Re : Application Number 19/01271/F

As requested I am writing to formally advise the planning committee of my objection to this application. The reasons I will outline below –

Drawing:
PLOT 2 – PROPOSED ELEVATIONS

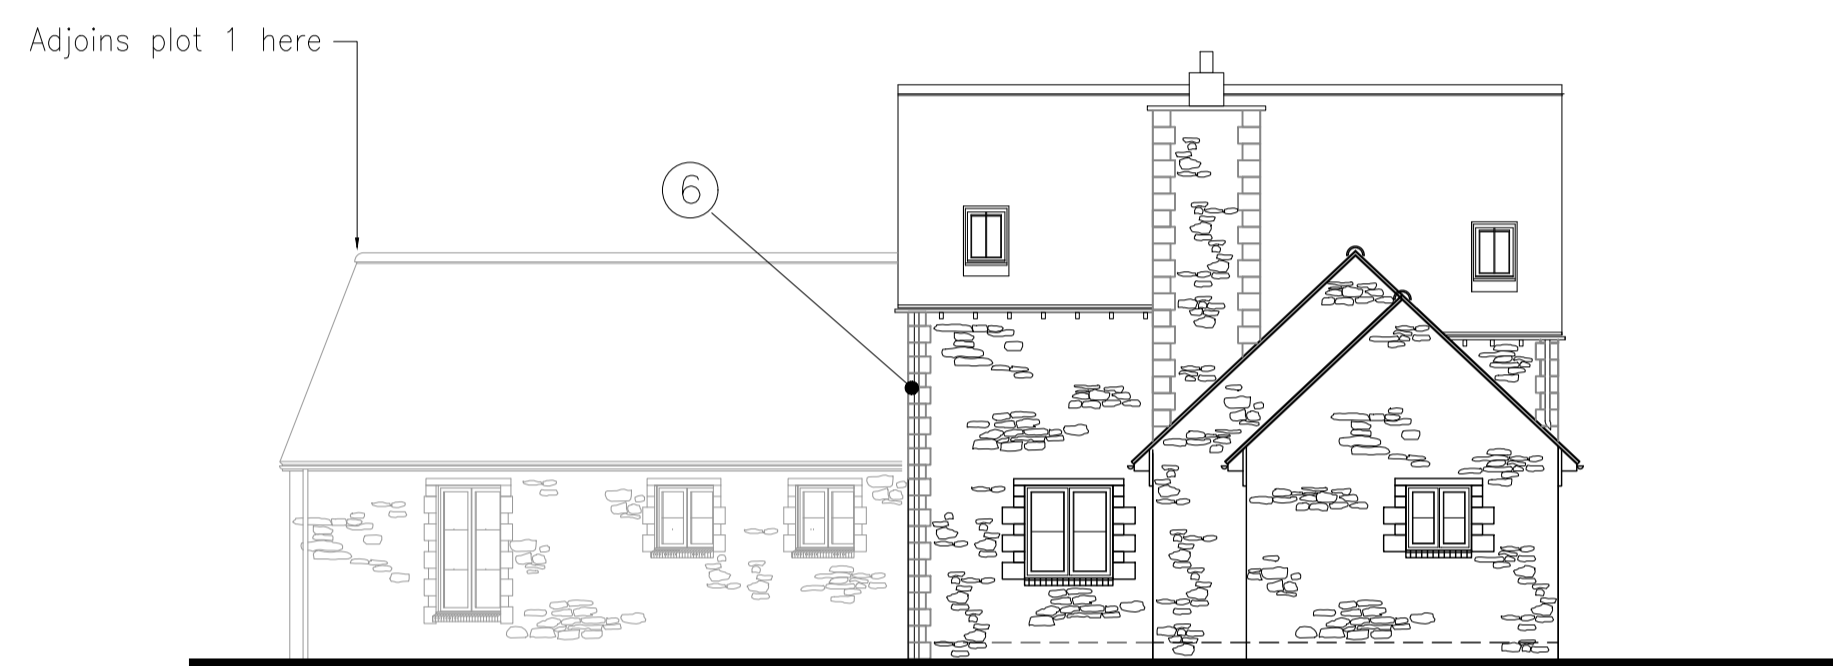
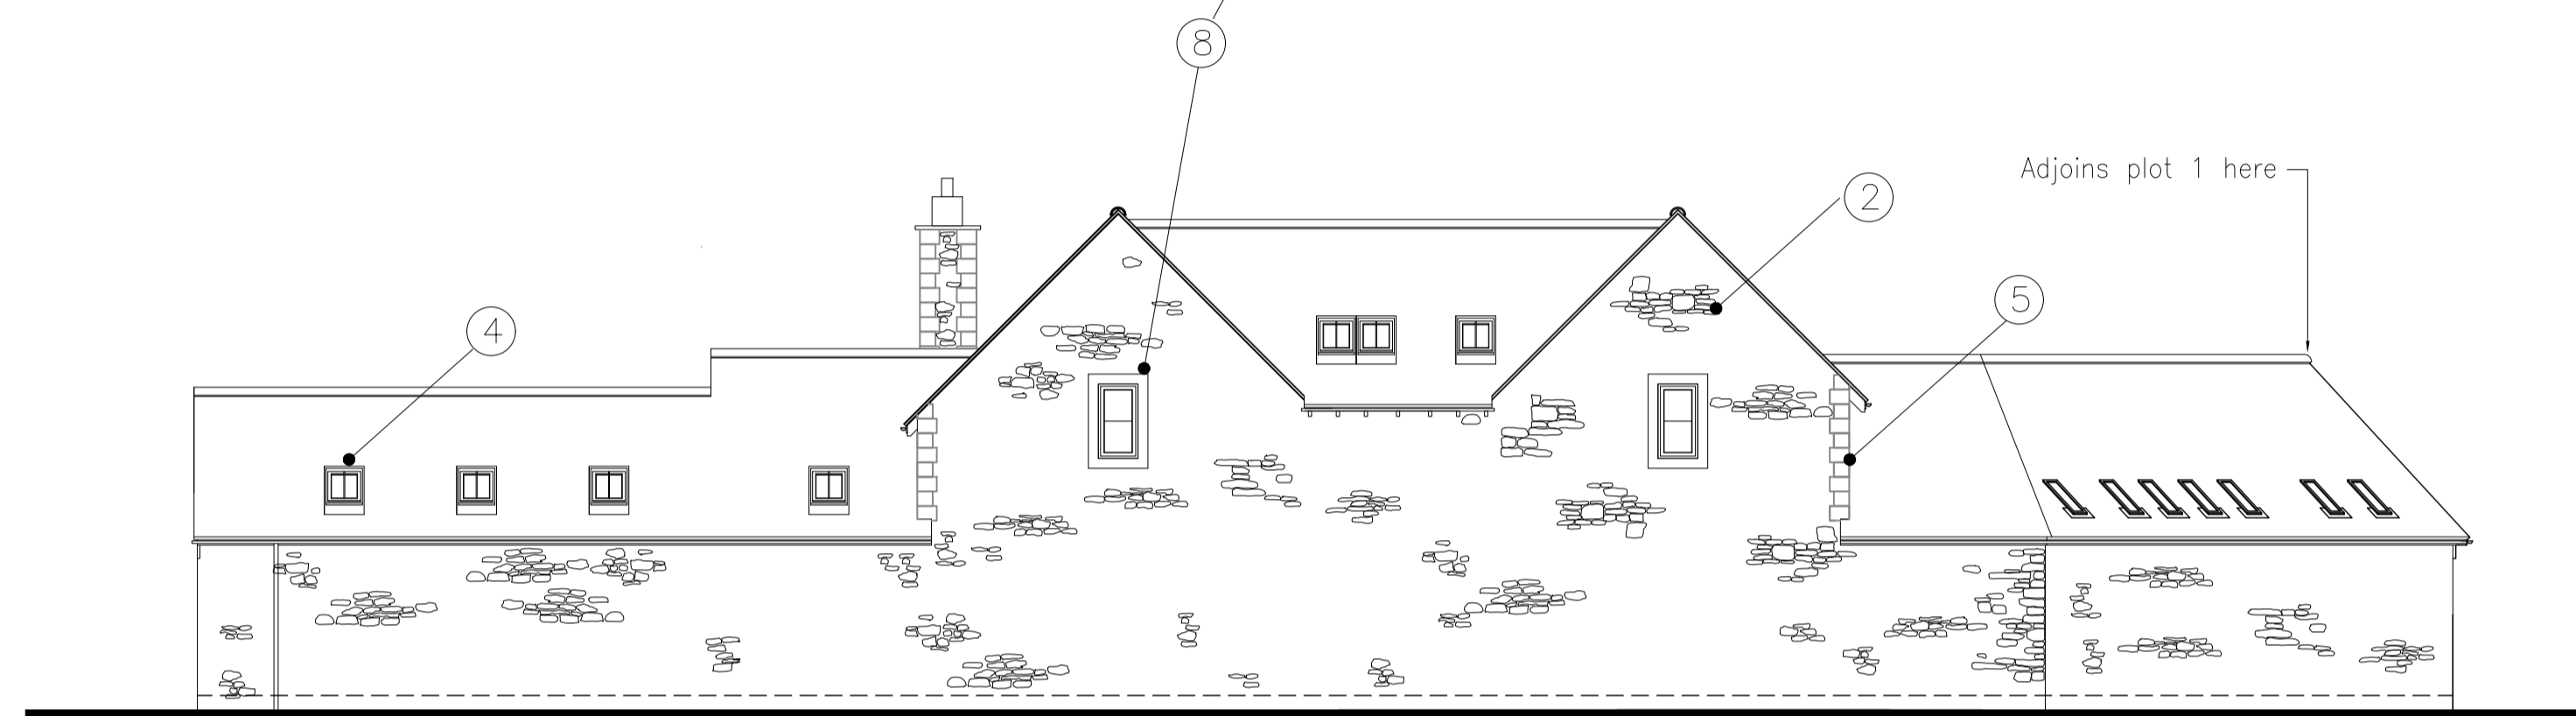
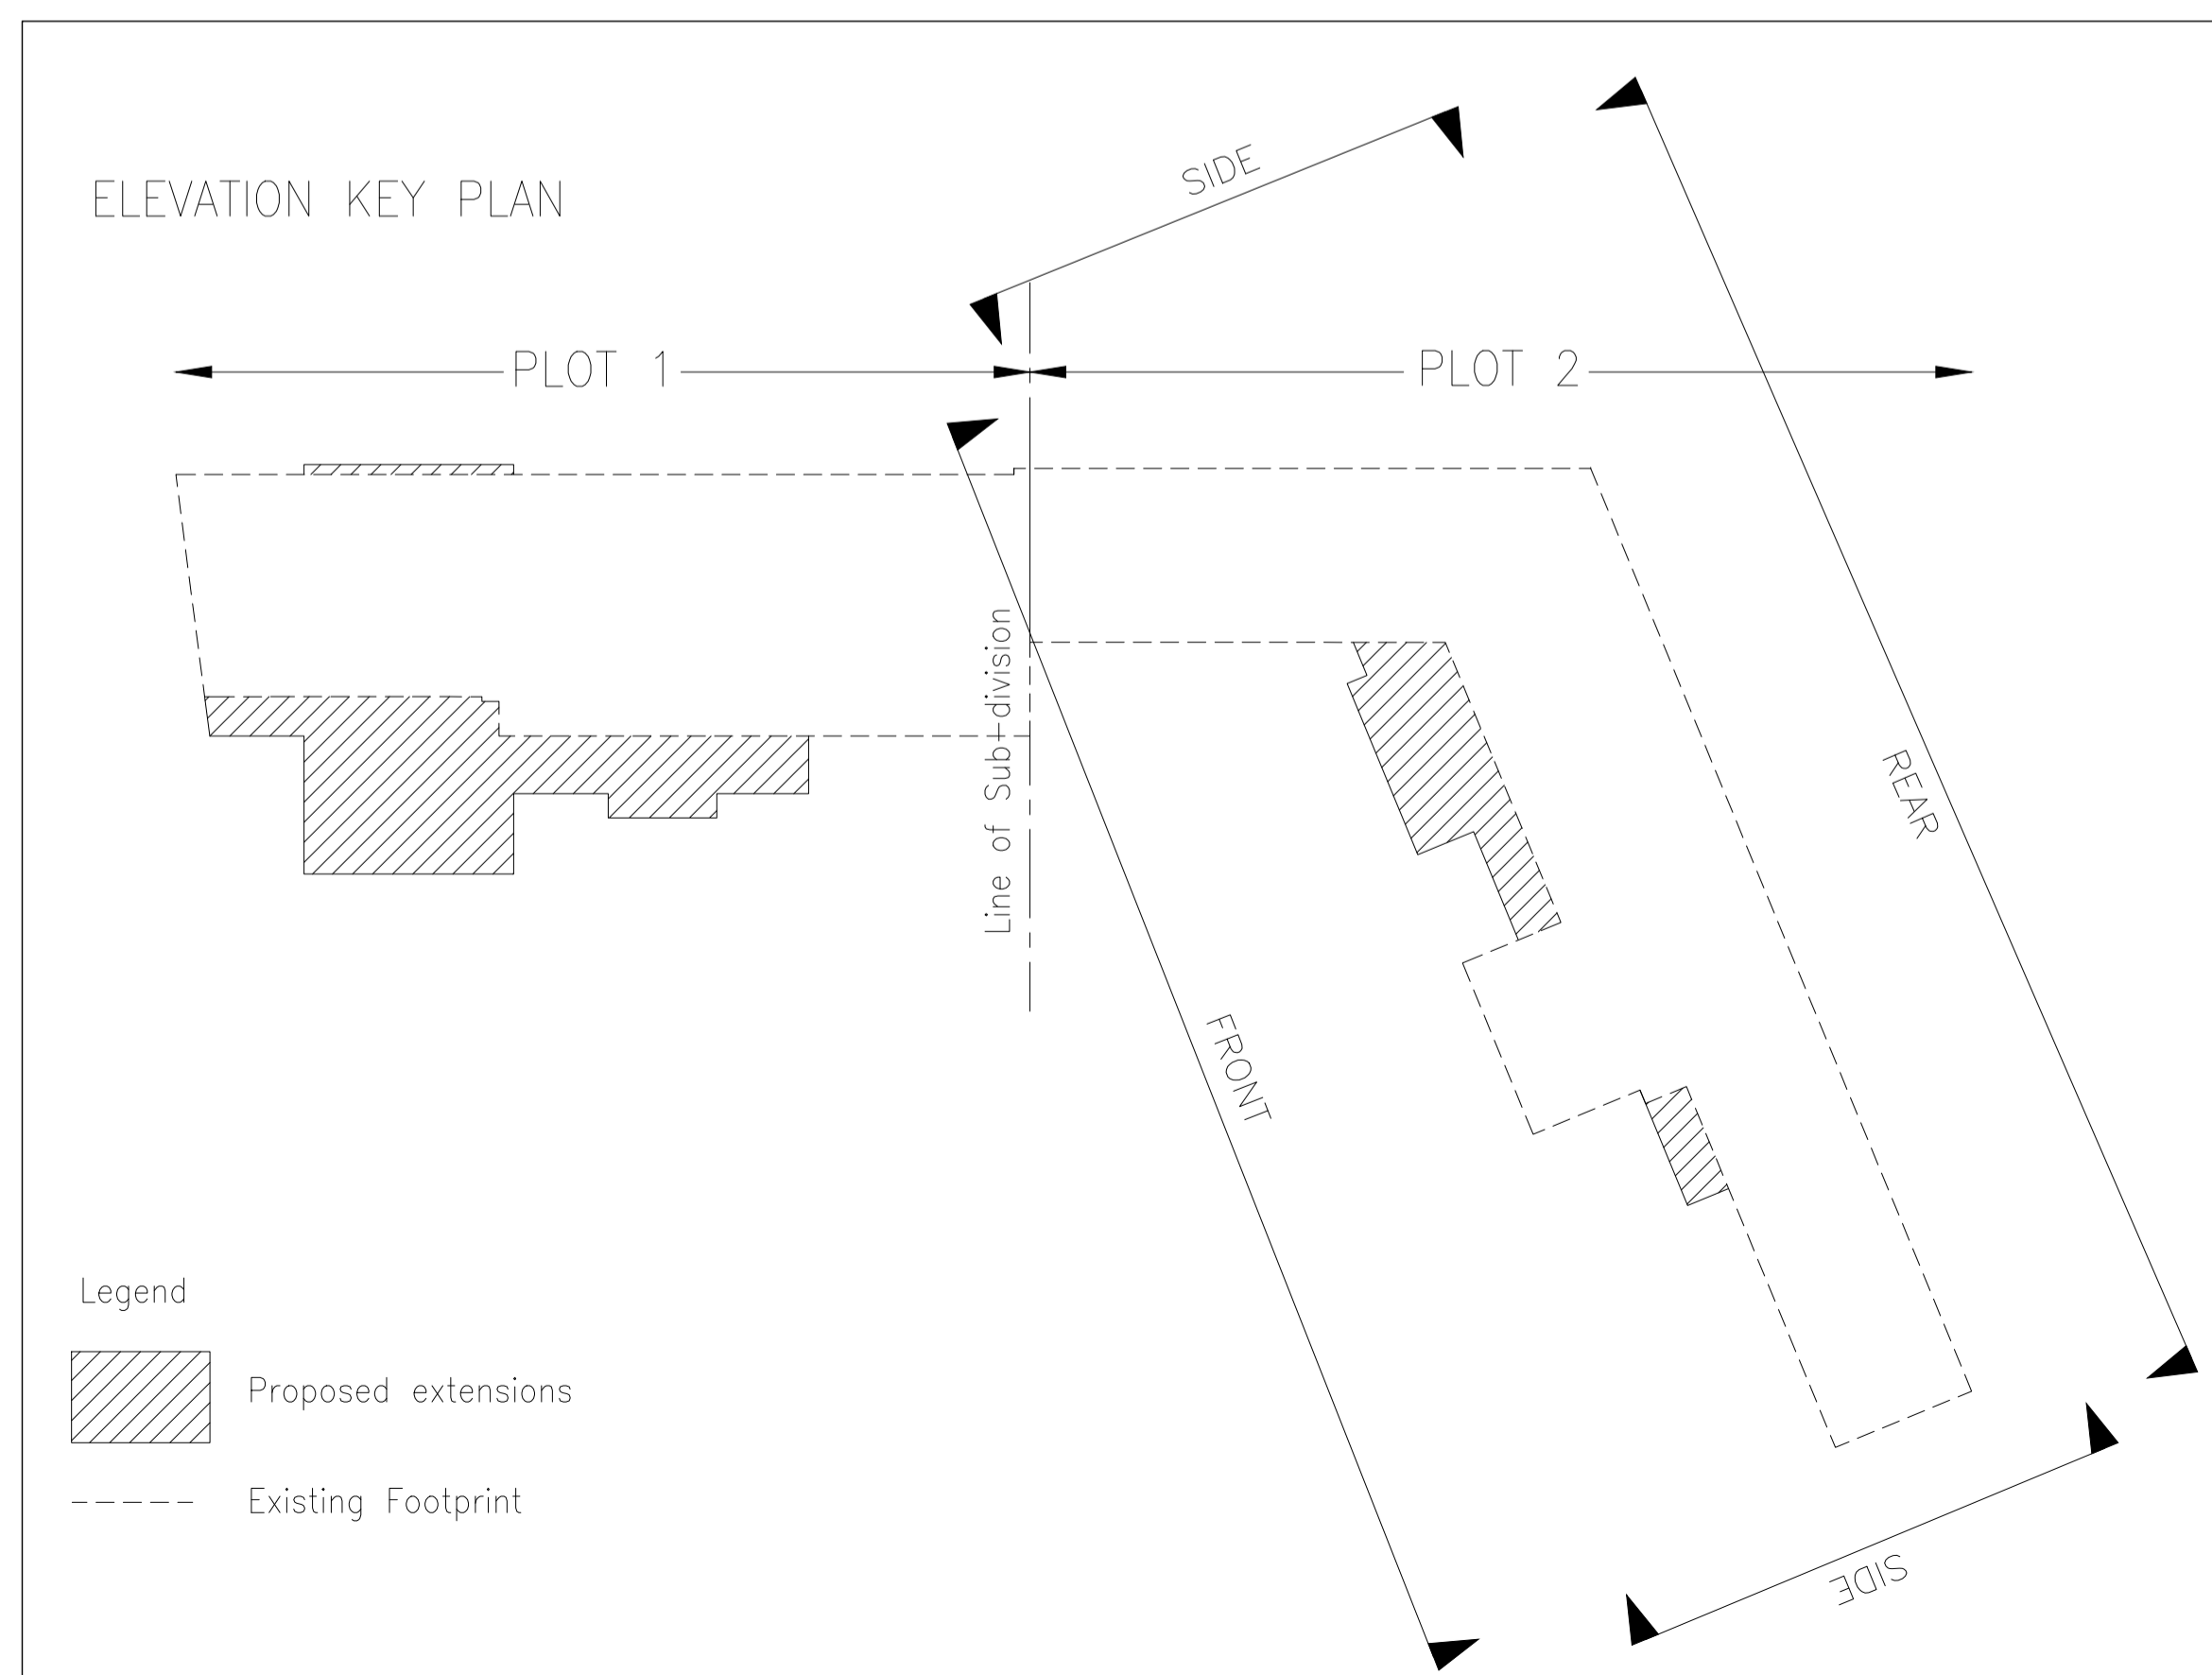
Design, appearance and materials – The design of the properties proposed will be nothing like the existing upon completion were it to be so. The volume of glazing proposed is extensive by comparison, the footprint significantly larger, the proposed garages are intrusive by nature in the context of Brashfield House. Overall the buildings proposed will be very modern in appearance, much like most modern day homes, not at all like the stable buildings of Brashfield House as they were and not at all in keeping with the surrounding buildings, it's history, architecture or heritage.
